RE: 261-269 Valley Street (former site of Eagles Club)
Accessory 10 space Parking Lot

CBL: 065 - H- 009 -001
Application ID: 09-79900010 (HTE)

To: Jean Fraser
From: David Margolis-Pineo - Public Services Review Comments
Re: Eagles Club Block
Maine Medical Center

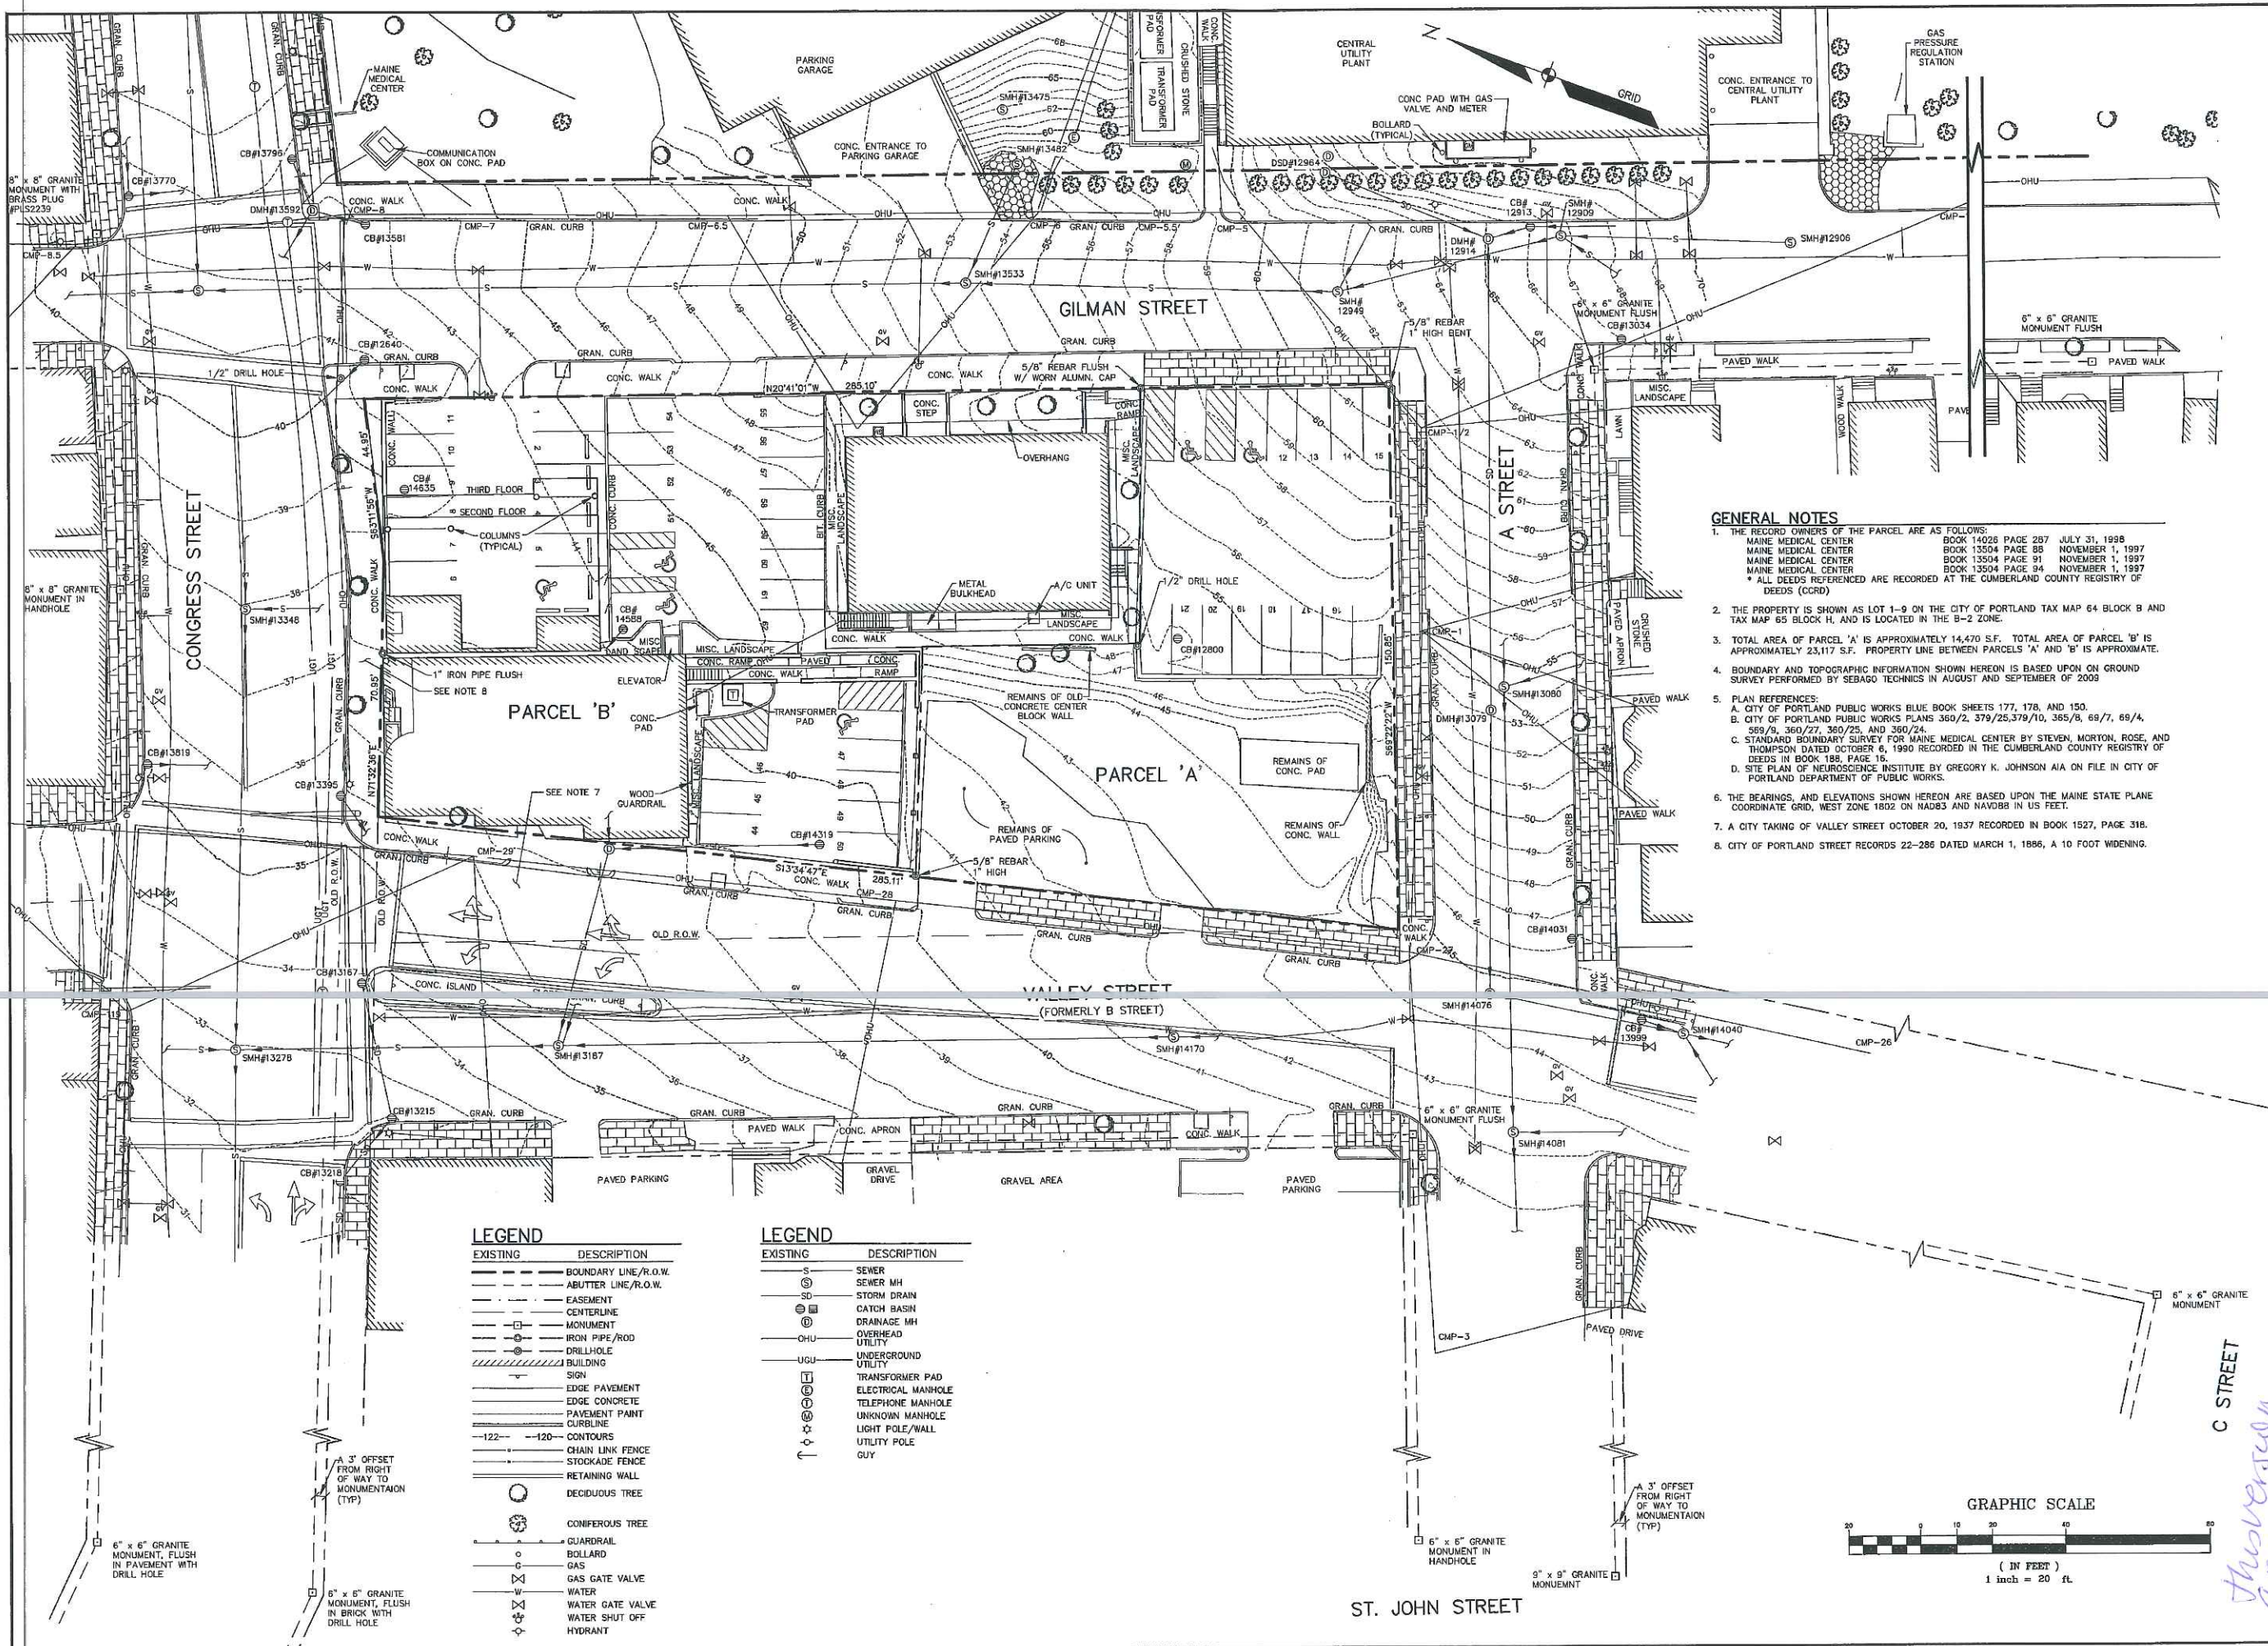
- ✓ 2. The applicant is requested to rebuild both sides of the proposed driveway cut to include granite tipdowns on both sides of the cut.
The applicant has shown both sides of the proposed driveway to include granite tipdowns. I would ask that the curb on both sides of the driveway cut be symmetrical and the shown granite "bug" not be installed.

One additional comment would be the thickness of base and finish asphalt pavement to be place in front of the curb. The pavement thickness dimensions are not show on the construction details. The asphalt base mix should be the thickness of the existing pavement allowing for one and half inches of surface mix. The minimum thickness for both the base and finish mix shall not be less than three and one half inches.
